App: LU/206/21/RES

Proposal: Approval of reserved matters following outline consent LU/47/11/ for the development of 260 No. dwellings and the construction of the Central Spine Road running through Hampton Park. This site is in CIL zone SP2 and is not CIL Liable as strategic site.

Address: Phase 5 Hampton Park Toddington Lane Littlehampton BN17 7PL

Landscape Strategy - Water
Meadows Edge

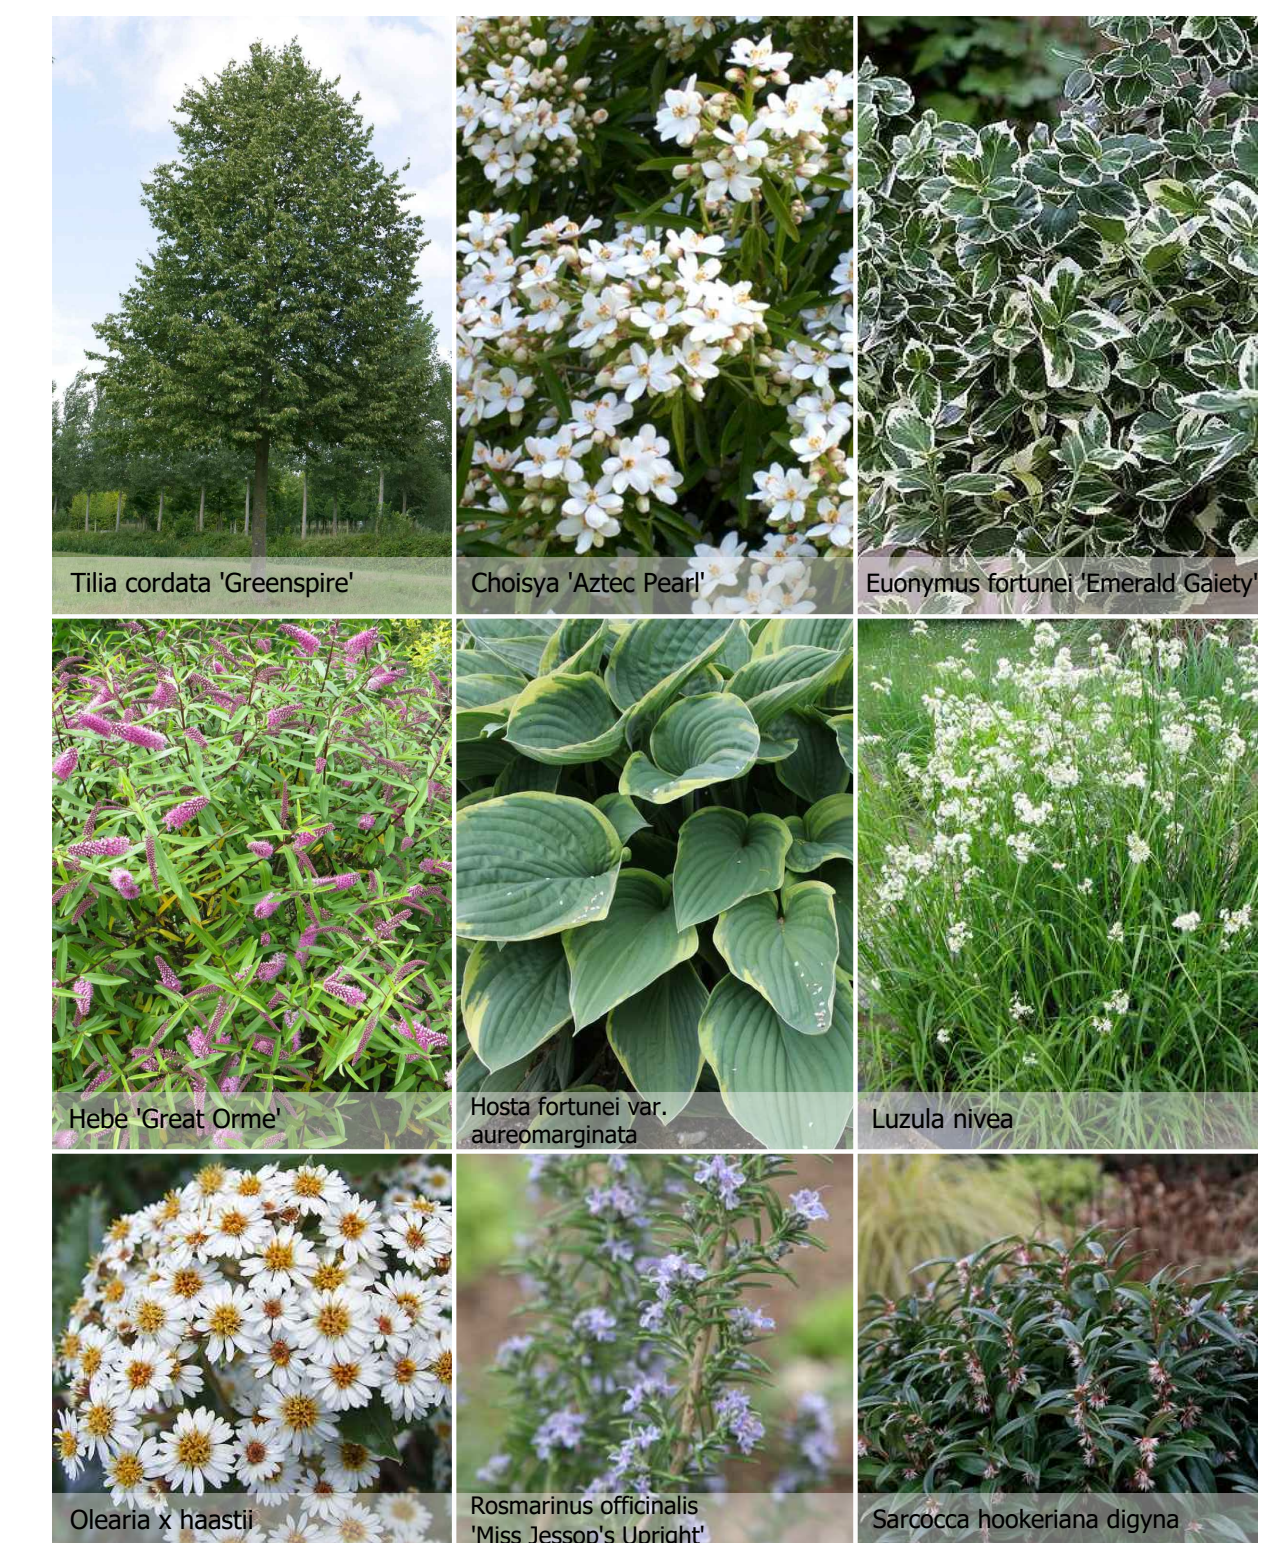
The Landscaping Strategy for the proposed central wetland is suitable. As per my colleagues comment (September 2021) we still require the scheme to confirm the timings of the proposed restoration.

As per my colleagues comment (September 2021), we require further enhancements across this parcel of land which should be incorporated into the scheme and shown on the landscaping strategy. This include;

- Grassland areas managed to benefit reptiles;
- We require that gaps are included at the bottom of the fences to allow movement of small mammals across the site;
- Two hedgehog nesting boxes included on the site
